Ribble Valley Borough Council  
Council Offices  
Church Walk,  
Clitheroe  
Lancashire  
BB7 2RA

Phone: 0300 123 6780  
Email: [Kathryn.Walsh@lancashire.gov.uk](mailto:Kathryn.Walsh@lancashire.gov.uk)  
Your ref: 3/2024/0913  
Our ref: 3/2024/0913/HDC/KW  
Date: 08 January 2025

**Location:** Land off Back Lane Chipping PR3 2QA  
**Proposal:** Proposed change of use of land to tourism and erection of five camping pods.  
**Grid Ref:** 361993 441328

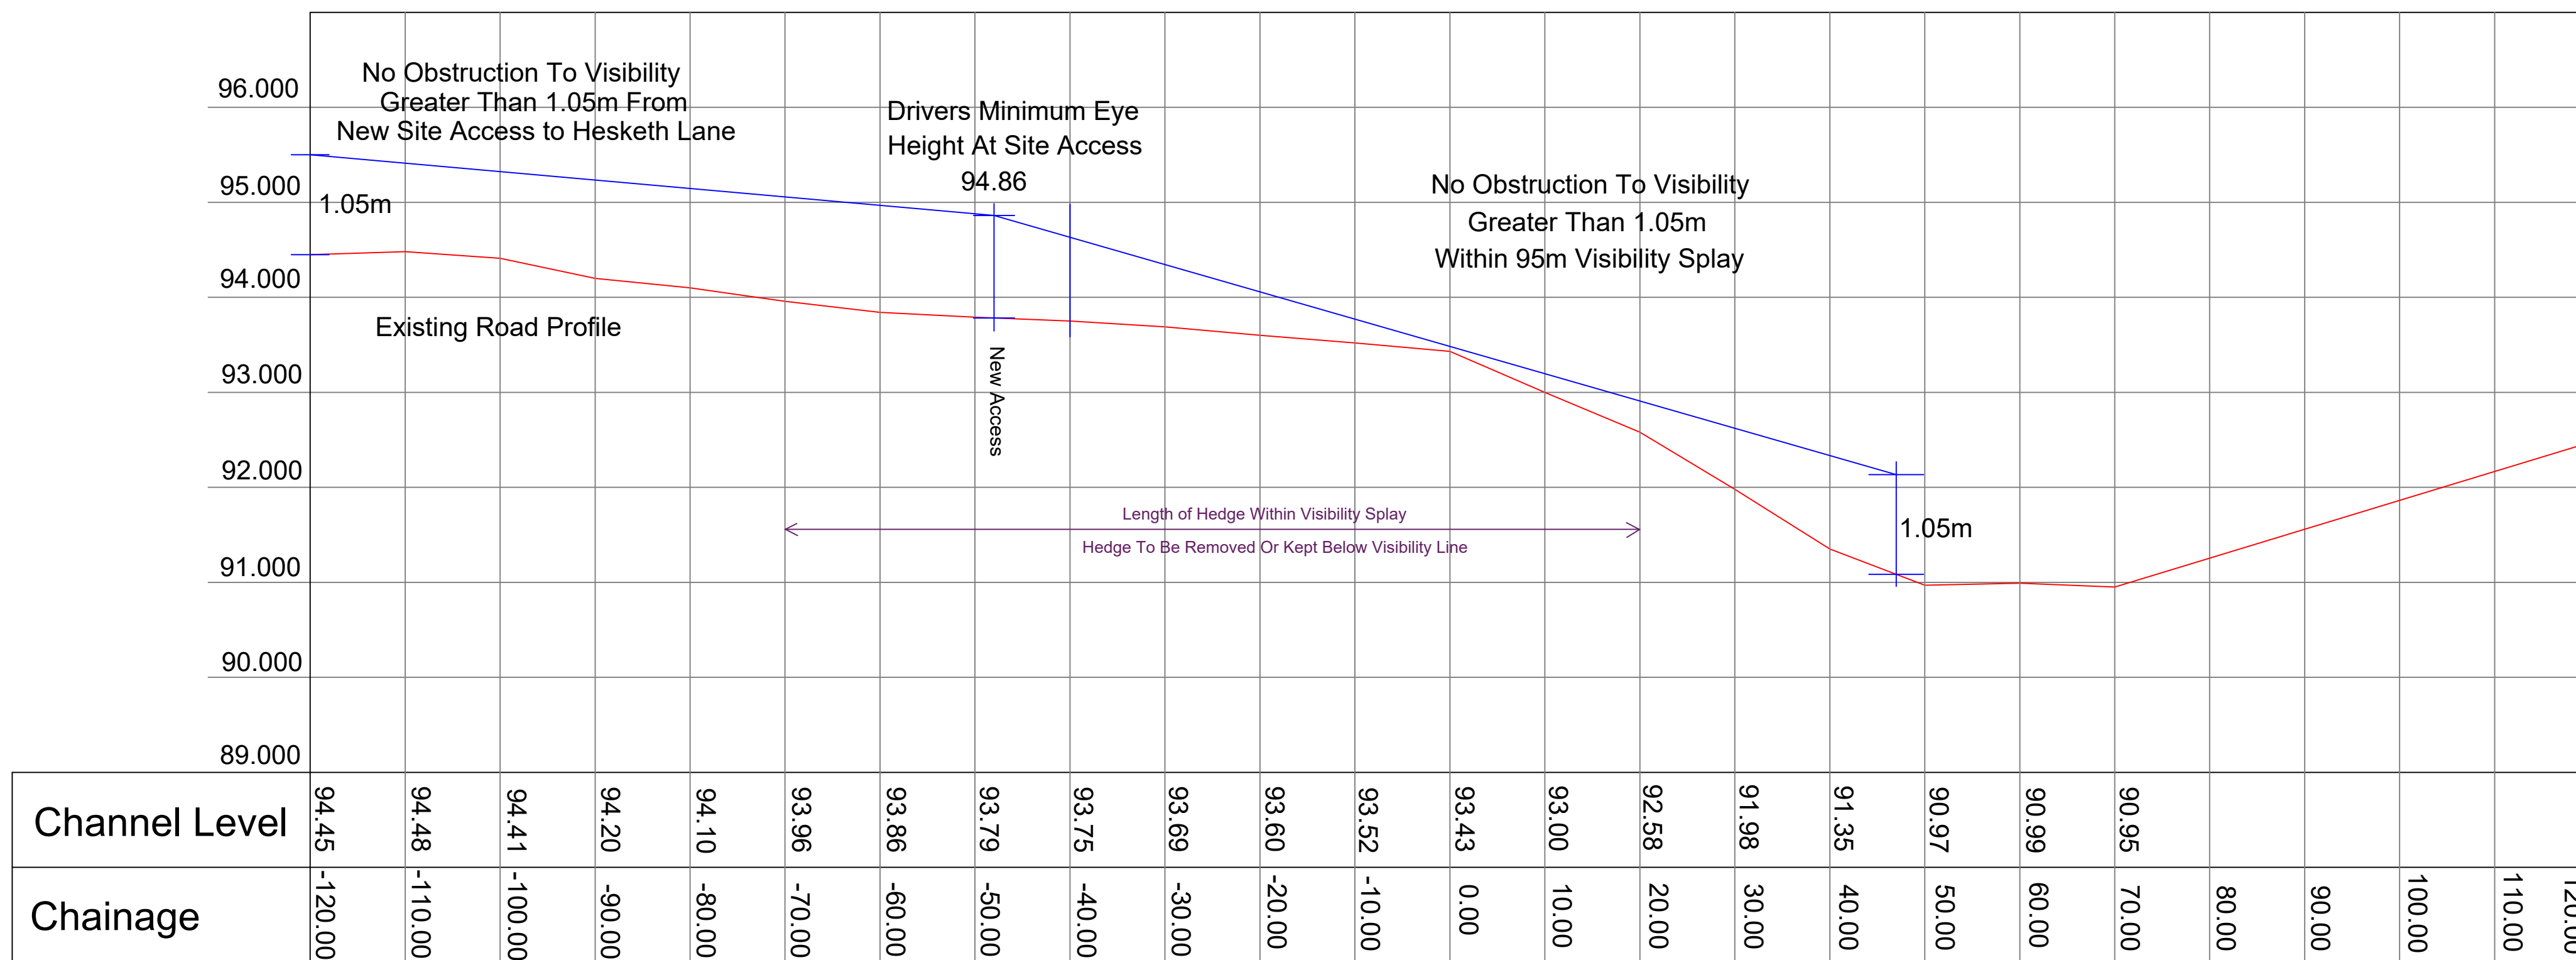
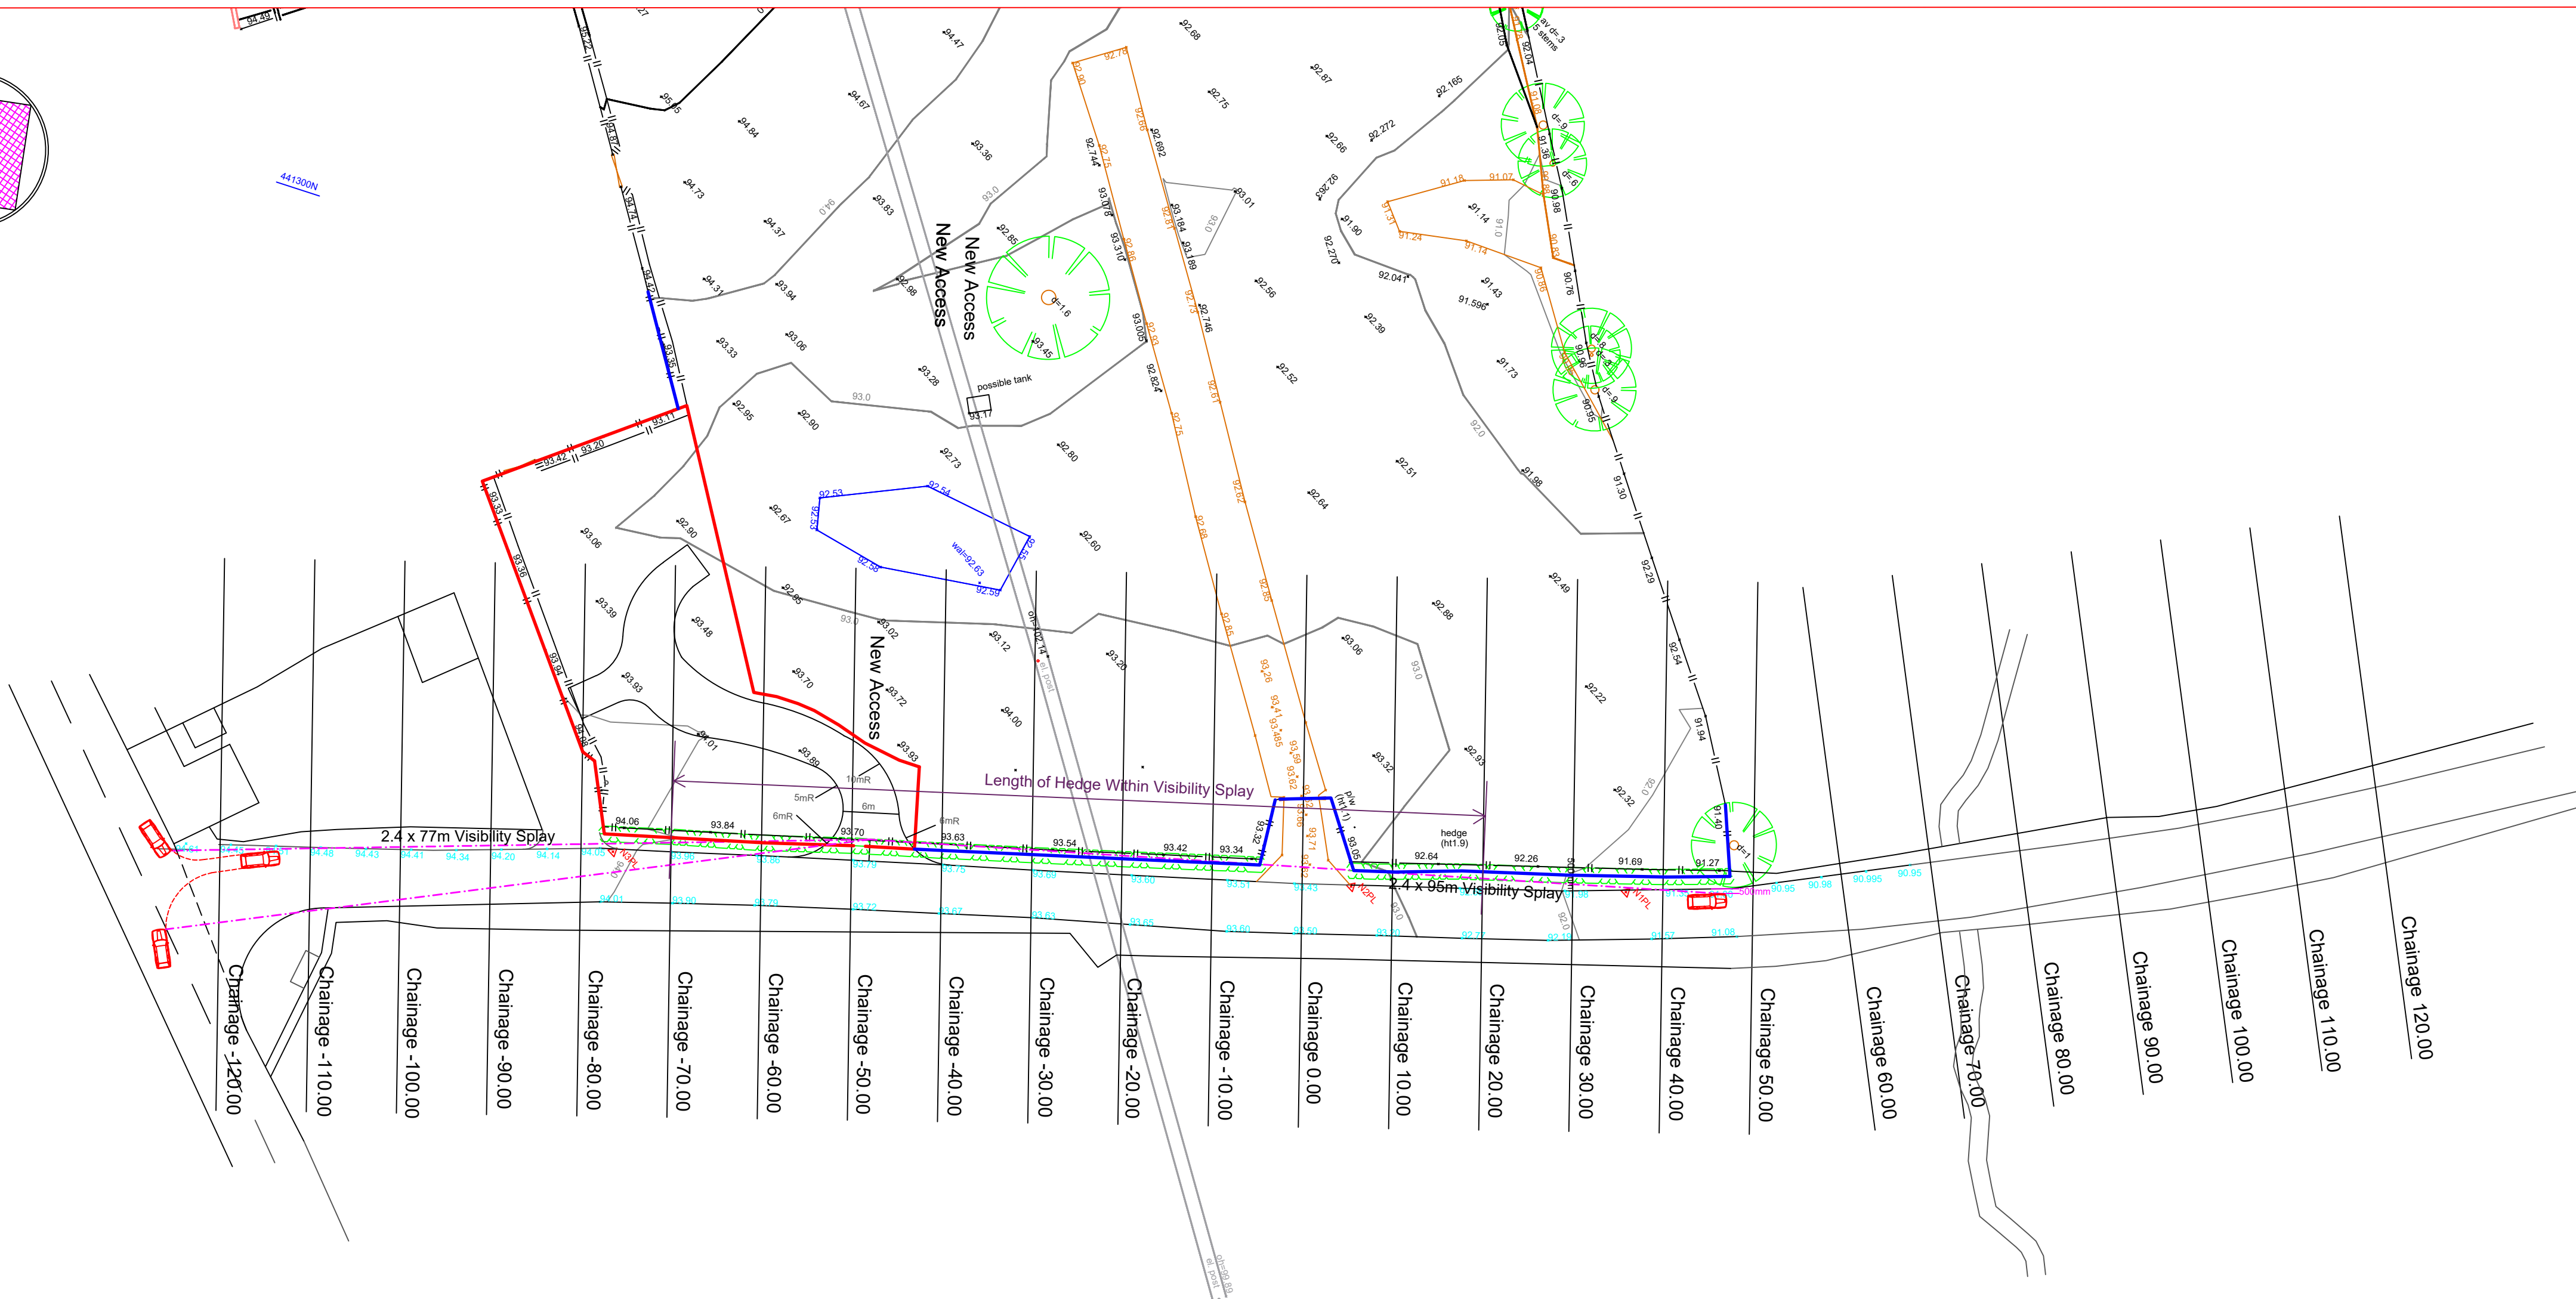
The applicant has failed to provide a detailed access plan which shows the width of the access as well as detailed sightline requirements although an estimated measurement taken from the proposed layout plan drawing number 21-019 0001 finds that the access is approximately 5m wide. As the proposal will intensify the use of the access, it is expected that the access be a minimum of 6m wide for 10m into the site, and be paved and drained. This will support two way vehicle movement. The LHA require visibility splays of 2.4m x 215m to be provided in both directions along Back Lane to comply with the LHAs guidance.

However, the LHA believes that the access is unlikely to achieve the necessary visibility splays for a 60mph speed limit due to the natural curve of Back Lane. The LHA has conducted an estimated visibility splay. The LHA found that the visibility splay would pass outside of the blue edge of the development and over third-party land.

Within the applicants blue edge, there is currently a hedgerow which bounds Back Lane, if this were to be reduced or removed the LHA are of the opinion that approximately a 50 metre visibility splay would be achievable to the right (north side) of the access which falls short of the required 215 metres by 165 metres. Consequently, the proposal would intensify the use of an access that lacks adequate visibility, posing significant highway safety concerns and contravening paragraphs 115 and 116 of the National Planning Policy Framework.
